DESIGN AND ACCESS STATEMENT

50 King Street,
Clitheroe

Planning Application submission for
Proposed Rebuilding of Rear Steps and Garage Alterations.
Job No: 2326 - 23.06.2017

IWA Architects

Proposed Rebuilding of Rear Steps - Option B

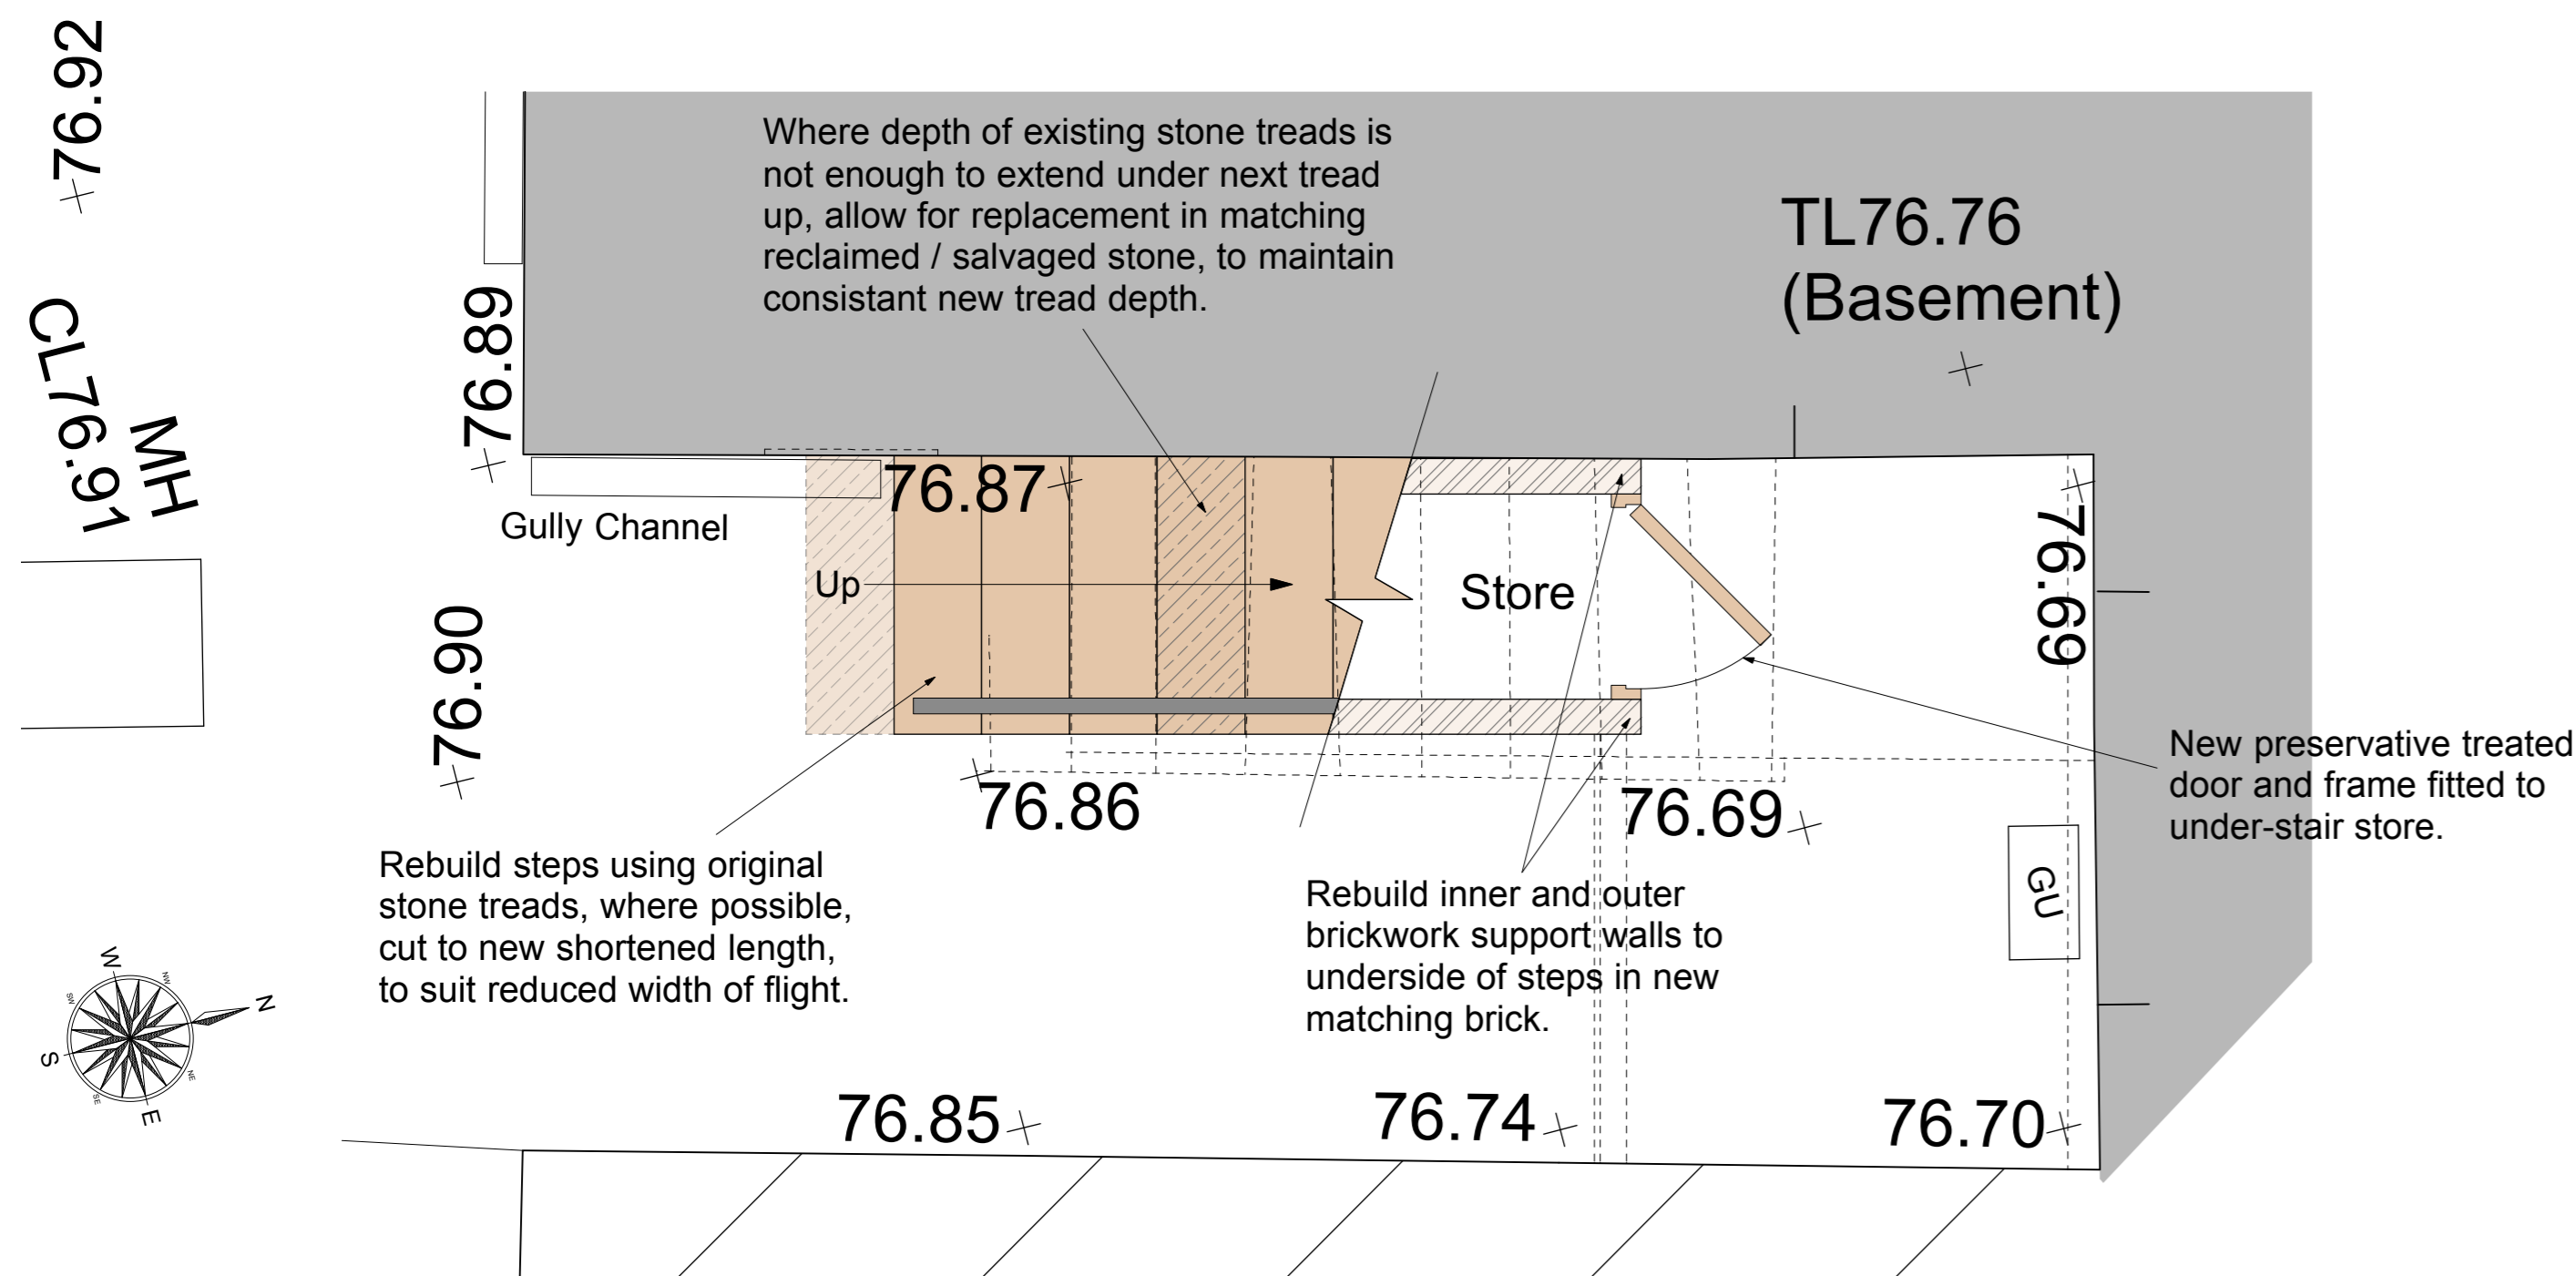
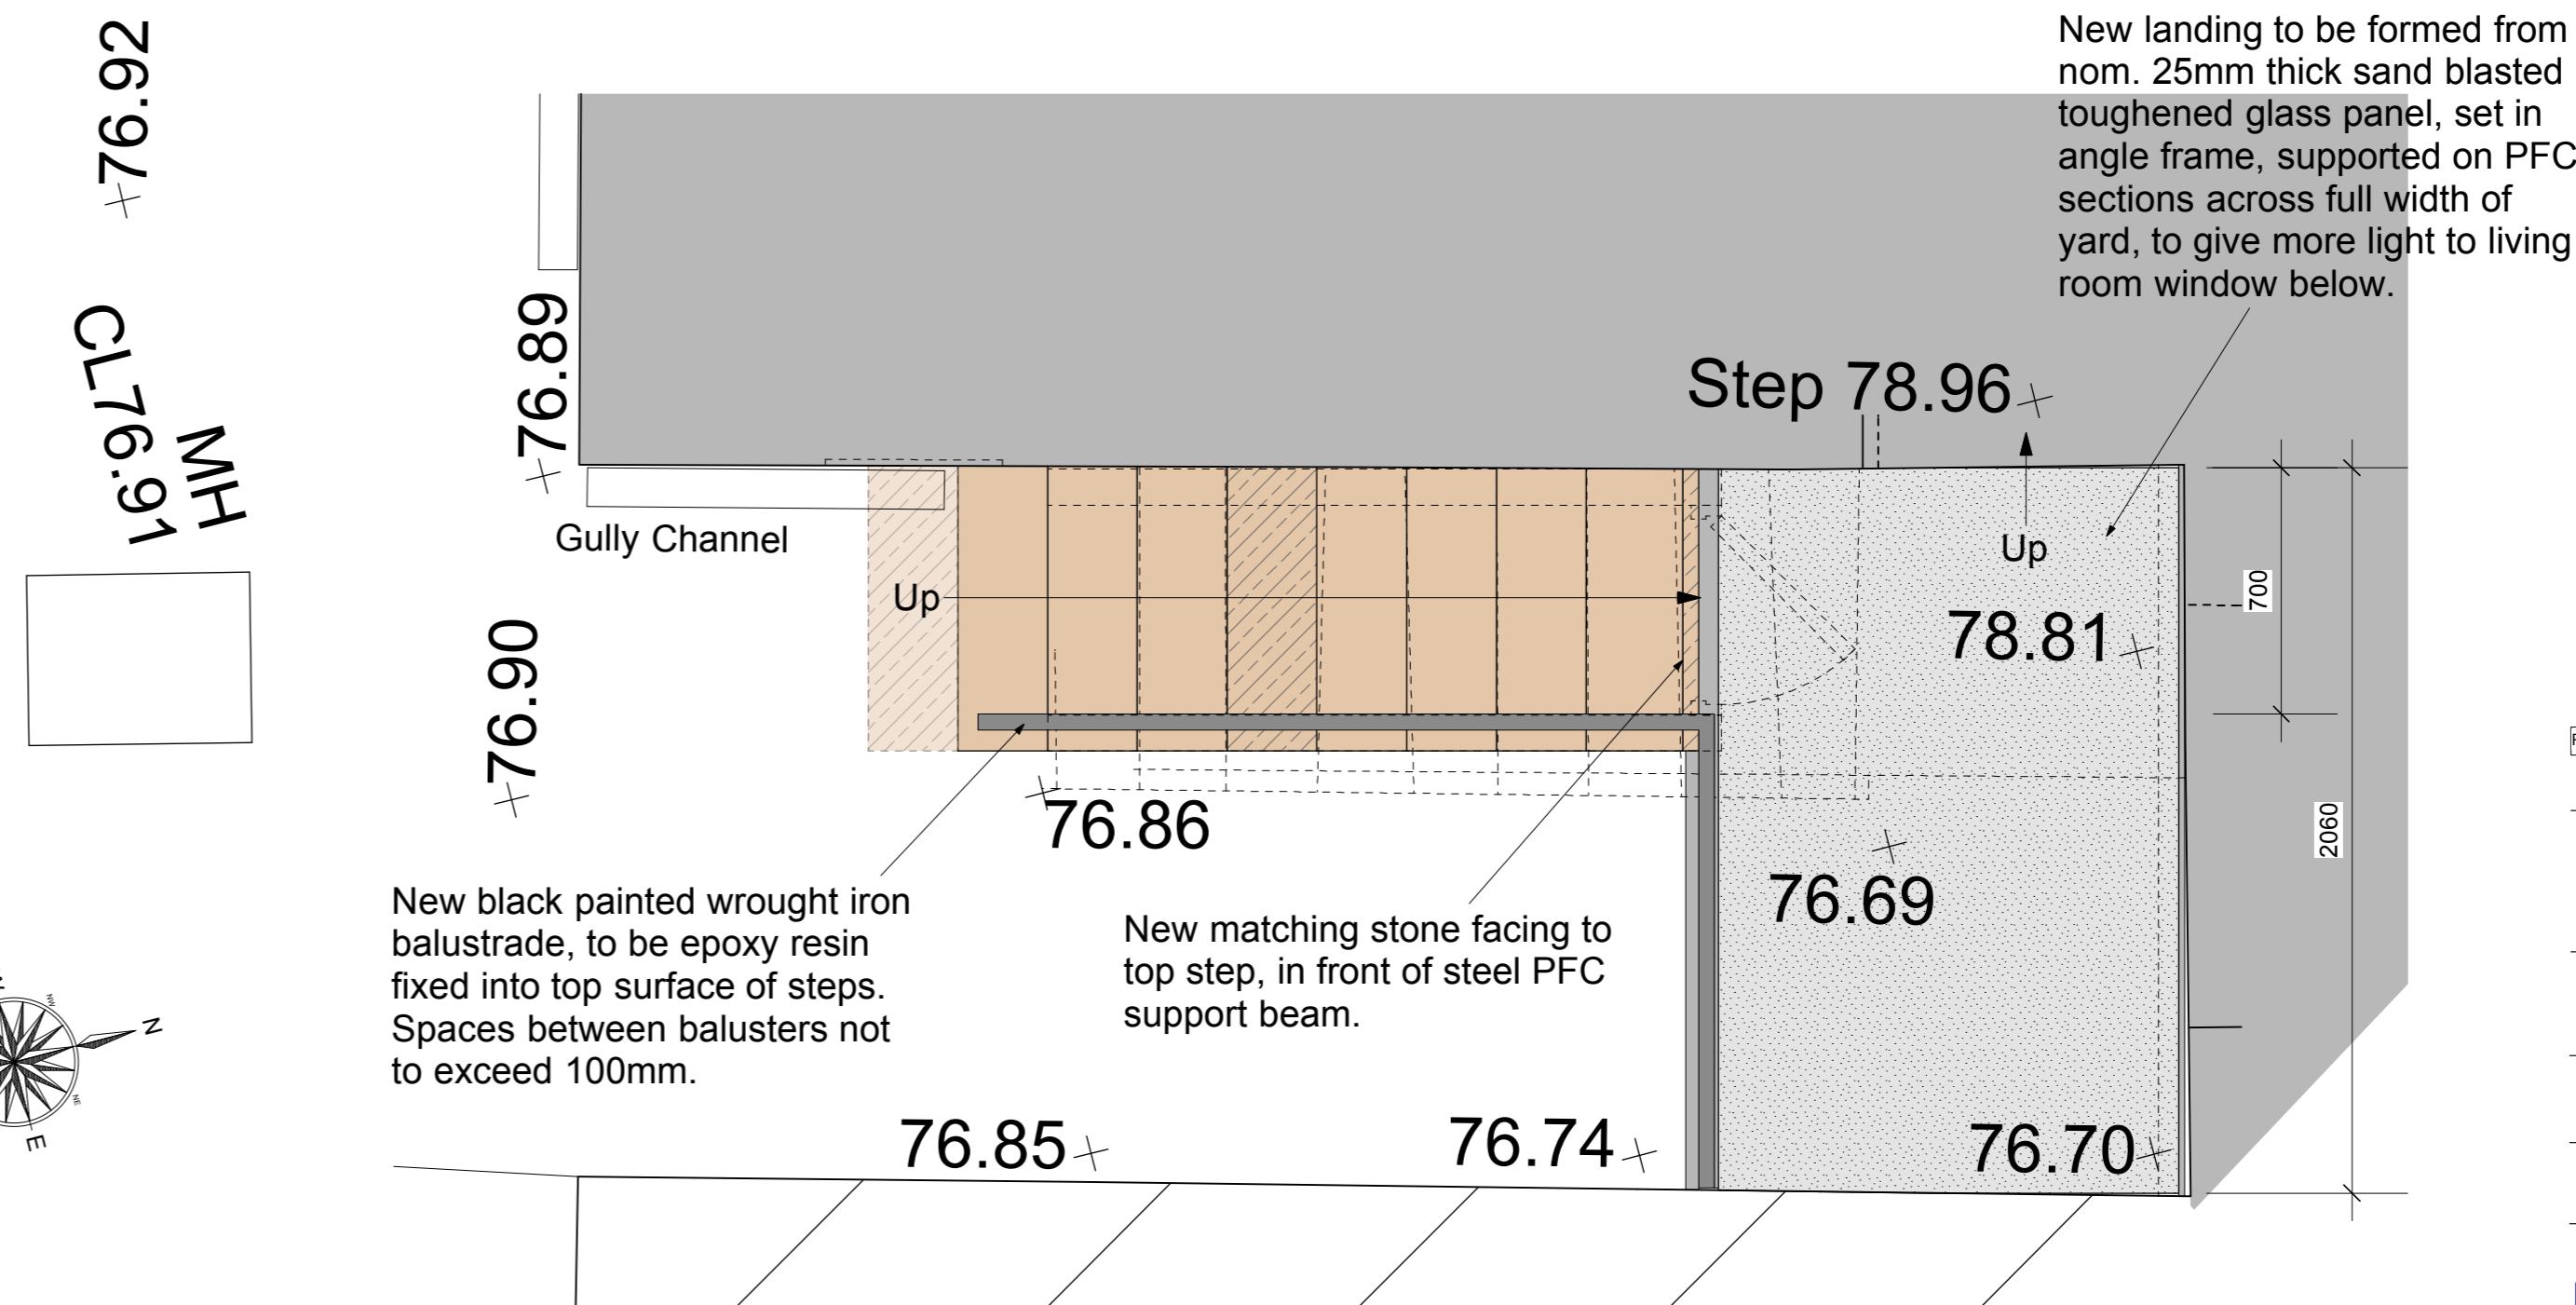
"... I have no objection in principle to the works that are proposed to the rear elevation of the property to create a new stairwell, landing and balustrade. I have no objection in principle to the replacement of the sloping roof to the garage with a pitched roof however not of the height proposed. In my opinion, the height of the building as a result of a replacement pitched roof should be no more than 3 metres. Materials to the
